Item No. **Report of the Head of Planning, Building Control, Sport & Green Spaces**

Address 3 BLOSSOM WAY HILLINGDON

Development: Two storey 6-bed detached dwelling with habitable roofspace, associated parking and amenity space involving demolition of existing detached dwelling

LBH Ref Nos: **8887/APP/2015/162**

PROPOSED SITE PLAN 1:500

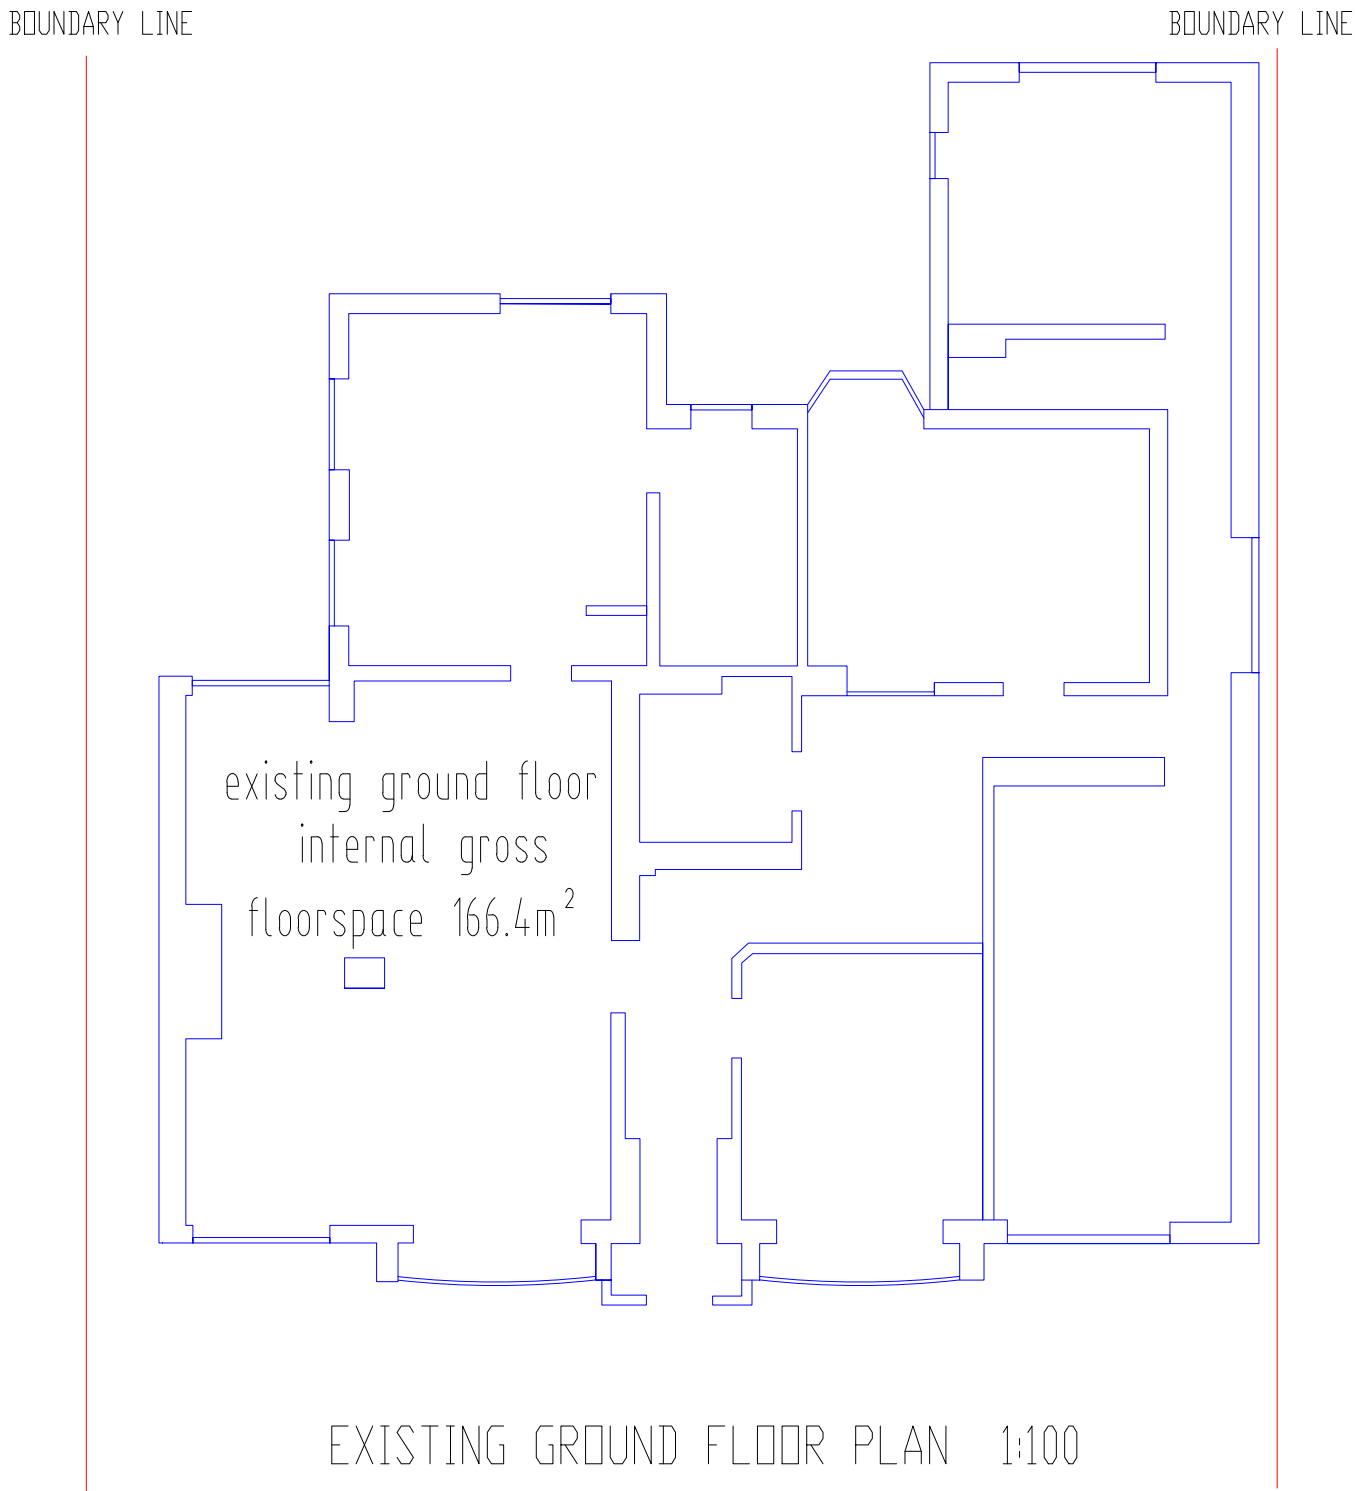
* Drawing No. FCP/3/2014/B indicates a similar site layout with an increased area of hard-standing for off-street parking in the front. A reasonable area should be retained as soft landscape in the front (at least 25%).

Although the landscape officer did not raise any objections, he stated that the boundary hedges should be protected during the construction phase. The plans indicate that there would be 1m high fencing/brick walls to the front boundaries of the property thus the assumption is that the hedge on both sides of the front garden would be removed. Hedges and trees are a prevailing feature within the locality and the removal of these soft landscaping features would be detrimental to the character and appearance of the street scene. Given also that there is currently a fairly large section of soft landscaping in the middle section of the front garden which is shown to be substantially reduced (although the Design & Access Statement suggests that at least 25% of soft landscaping would remain) and the front garden mainly to be laid to gravel, the fencing/brick walls would add to the hard landscaping creating a completely different feel to the somewhat green streetscape and this would be unacceptable under the auspices of Policy BE38.

PROPOSED GROUND FLOOR PLAN (OPTION 3) 1:100

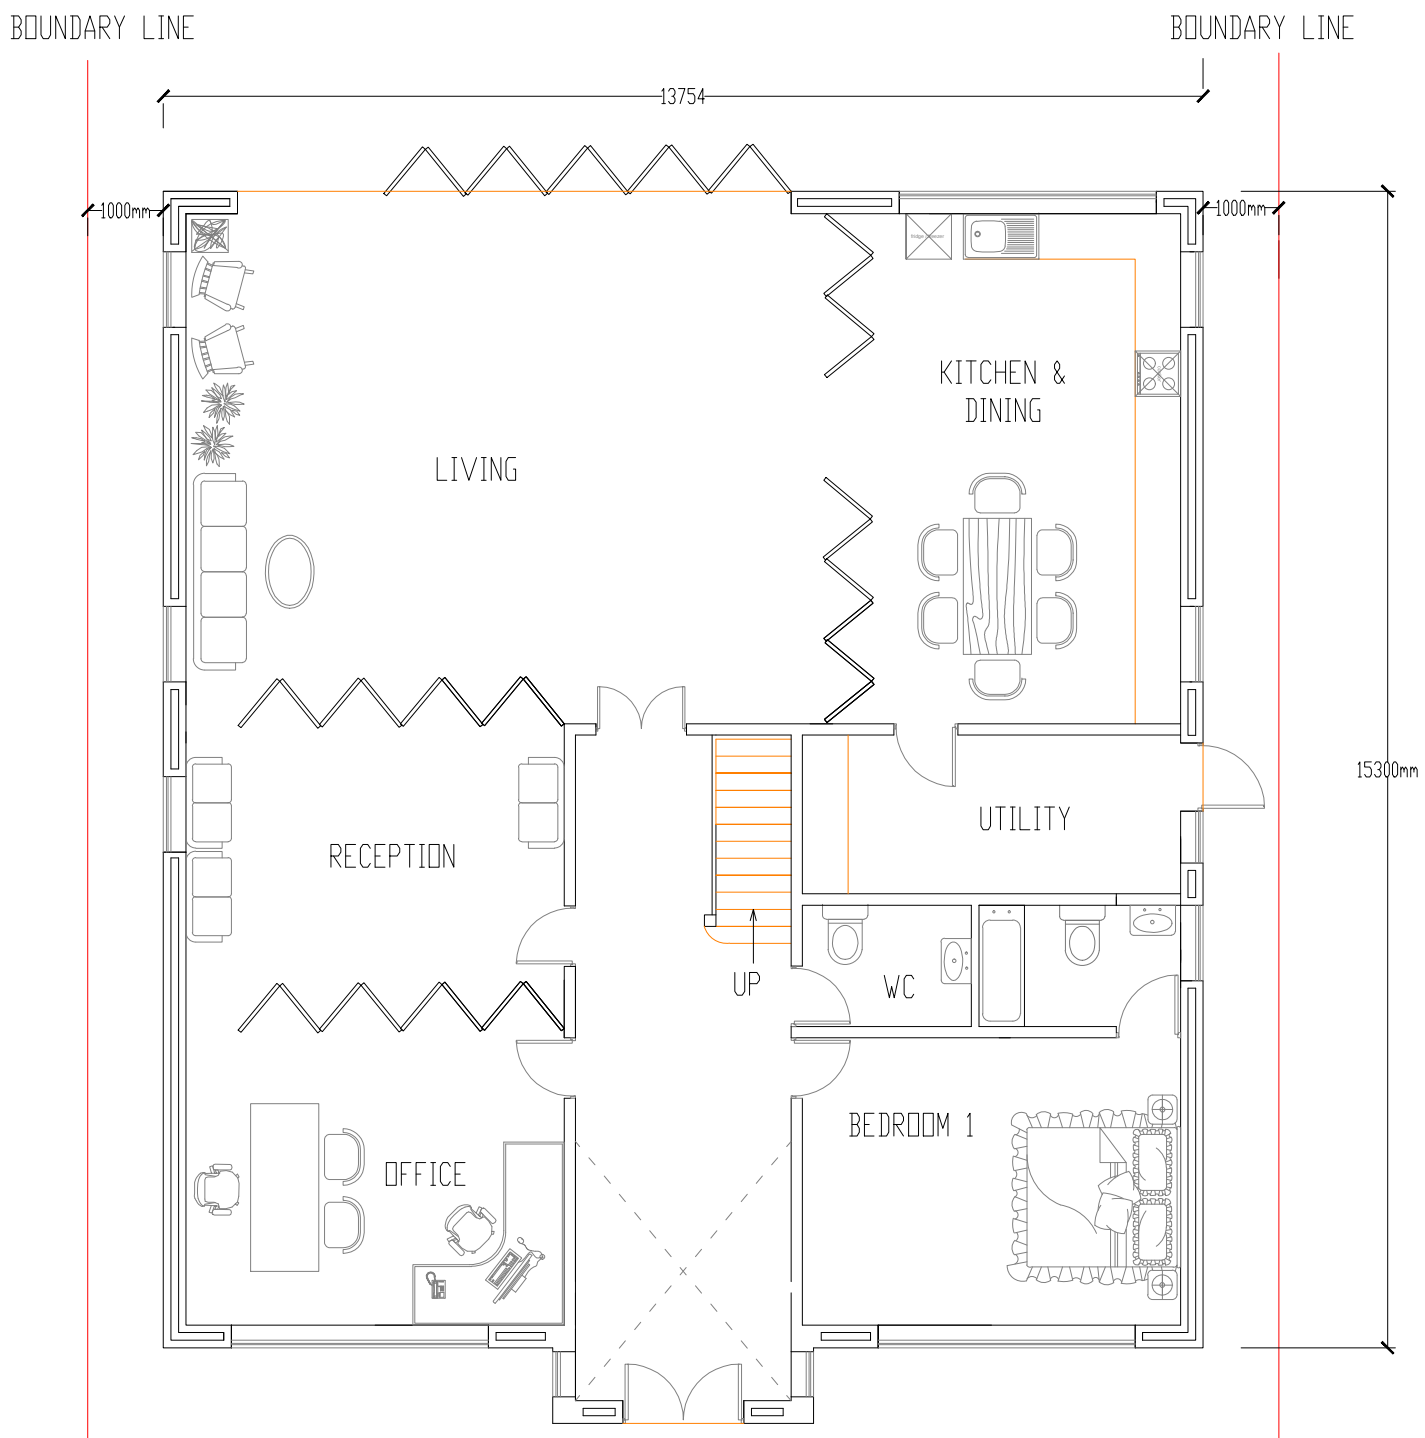
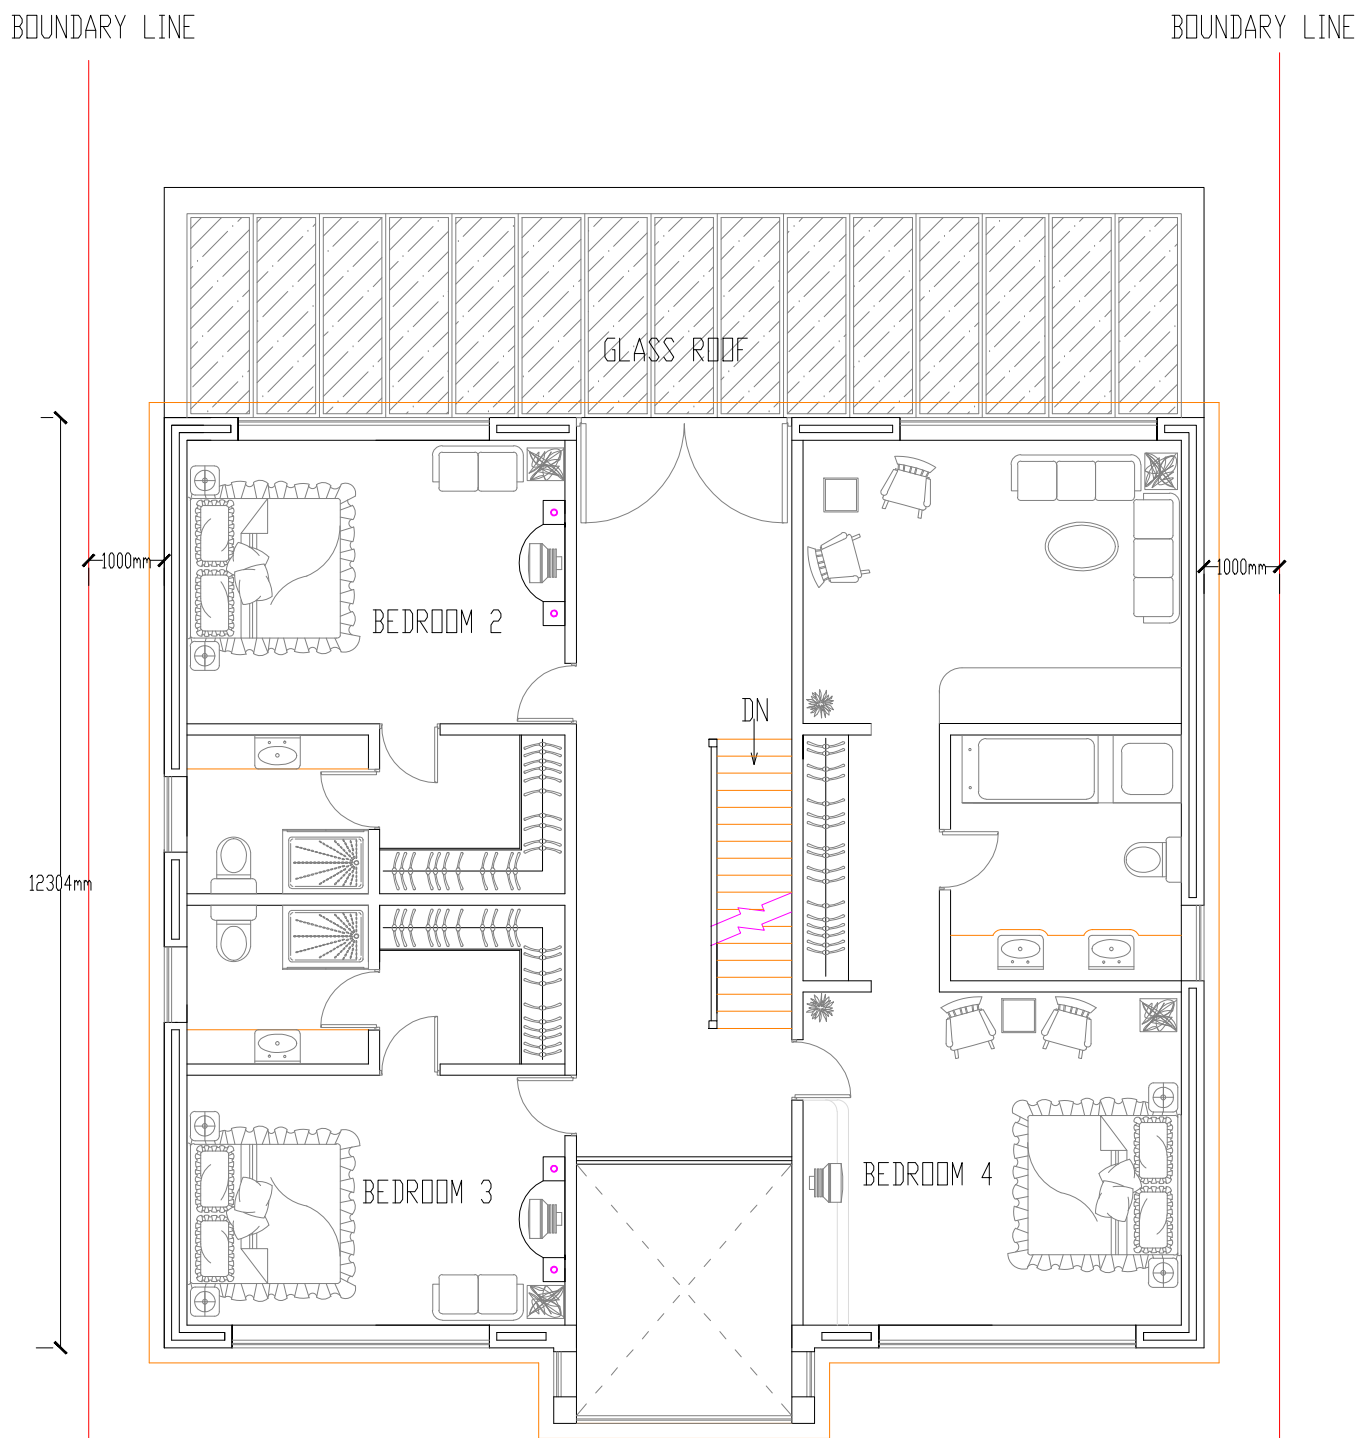
The Design & Access Statement states the proposal is to meet the Lifetime Home Standards, but the requisite specifications are not included in the plans. Compliance with

all 16 Lifetime Home standards (as relevant) should be shown on plan. The following access observations are made:

1. Level access should be achieved. A fall of 1:60 in the areas local to the principal entrance and rear entrance should be incorporated to prevent rain and surface water ingress. In addition to a levels plan showing internal and external levels, a section drawing of the level access threshold substructure, and water bar to be installed including any necessary drainage should be submitted.

2. The scheme does not include provision of a downstairs WC compliant with the Lifetime Home requirements. To this end, a minimum of 700mm should be provided to one side of the toilet pan, with 1100mm in front to any obstruction opposite.

3. A minimum of one bathroom on the first floor should be designed in accordance with Lifetime Home standards. At least 700mm should be provided to one side of the WC, with 1100mm provided between the front edge of the toilet pan and a door or wall opposite.

4. To allow the entrance level WC and first floor bathroom to be used as a wet room in future, plans should indicate floor gulley drainage.
5. The plans should indicate the location of a future 'through the ceiling' wheelchair lift.

Conclusion: revised plans should be requested as a prerequisite to any planning approval. In any case, an additional Condition, as set out below, should be attached to any planning permission:

PROPOSED FRONT ELEVATION (OPTION 3) 1:100

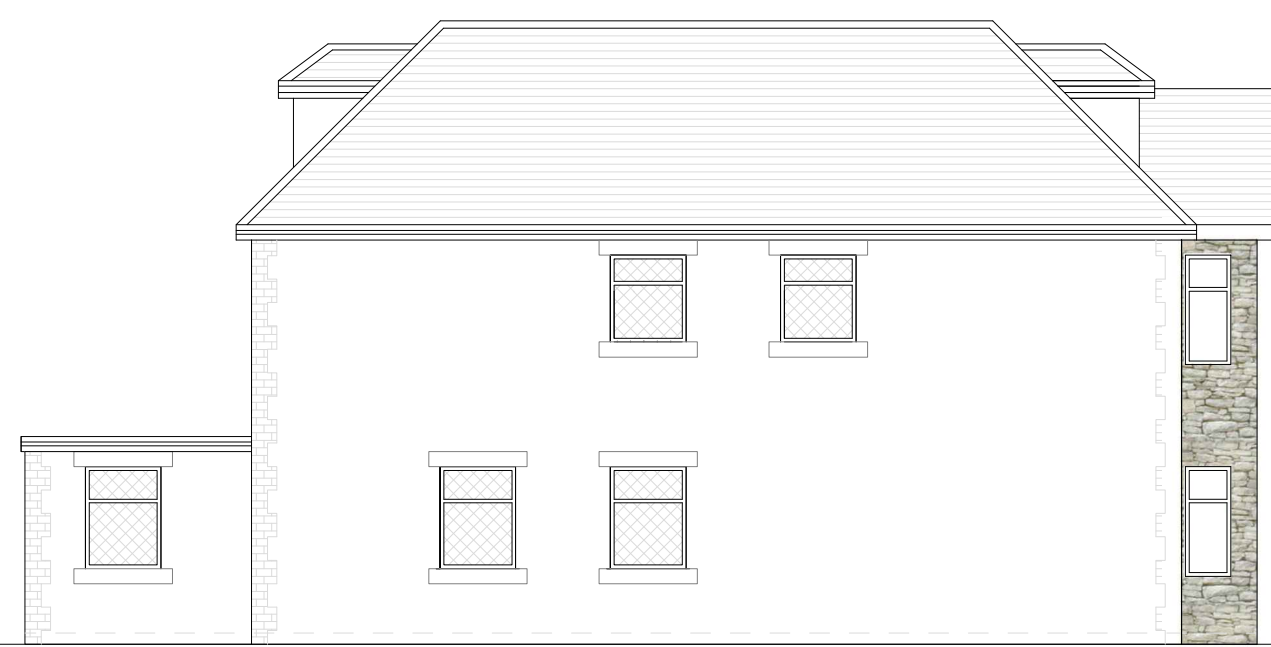
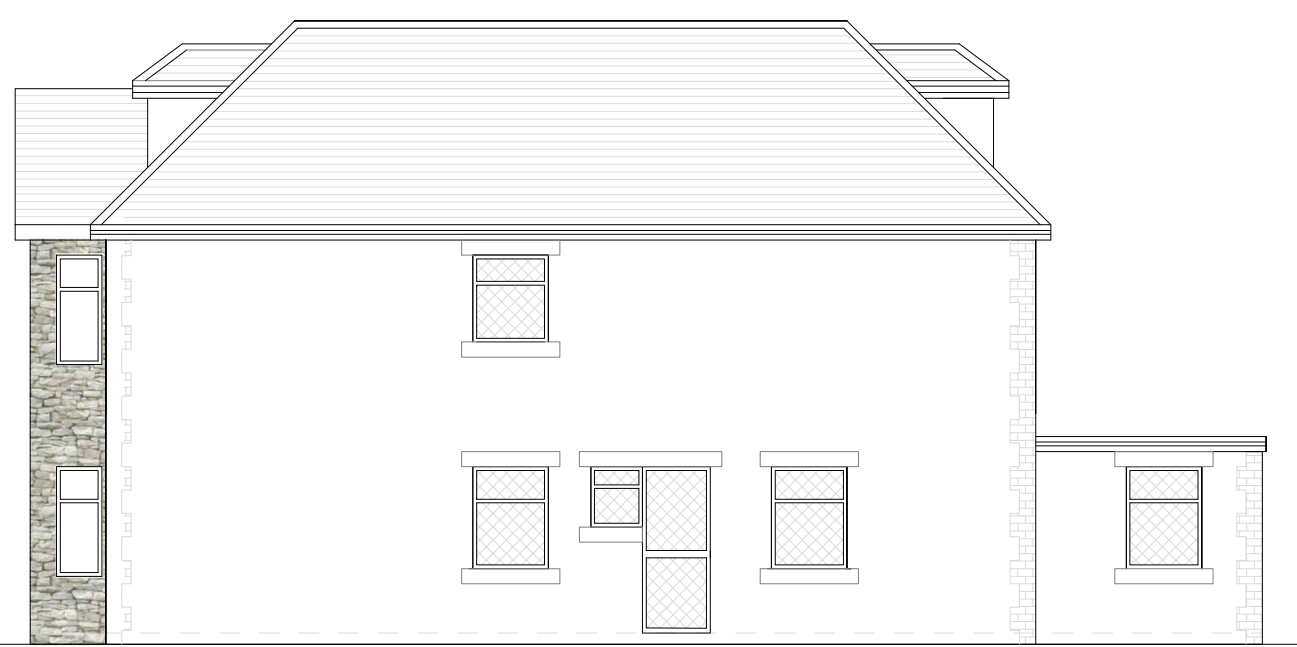
In comparison the proposed dwelling would have a ridge height of 8.15m, with an eaves height of 5.2m. The ground floor would also include a single-storey flat roof extension and the overall depth of the house at ground floor level would be 15.3m with the first floor having a slightly reduced depth of 12.7m. The height of the roof has been kept artificially low with the inclusion of a part hip, part flat 'crown' roof which gives it a squat appearance out of proportion with the main elevations.

There would be 2 obscurely glazed first floor windows (serving en-suite bathrooms) within the west elevation (facing towards the rear of the dwellings in Honey Hill. On the east side there is proposed 1 similar size obscure glazed window on the first floor also serving a further bedroom.

The rears of the affected properties within Honey Hill (namely no's 20 and 21) are 11m and 13m respectively. The proposal would introduce a two storey wall within 11m and 13m respectively of the rear elevation habitable room windows at No. 20 and 21 Honey Hill. This is well below the distance recommended in the HDAS of 15m and therefore it is considered that the proposed house would have an overbearing and visually intrusive impact upon these properties, contrary to Local Plan policy BE21.

The HDAS recommends a separation distance of 21m between habitable facing windows. The windows on the side elevations serve bathrooms and are to be obscurely glazed. There is a distance of 11m between the side flank wall and the habitable rooms on the rear of 20 Honey Hill. However as the bathroom windows would be obscurely glazed it would not be considered that these windows would create any direct overlooking. There would be some oblique overlooking from the rear first floor and rear dormer windows mainly into the rear gardens of no's 19 and 20 Honey Hill which may give a perceived sense of being overlooked by these windows. However, they are of a sufficient distance from the rear rooms and patio areas of these properties and it is not considered that the amount of overlooking would result in a significant loss of privacy which would warrant a refusal based on these grounds.
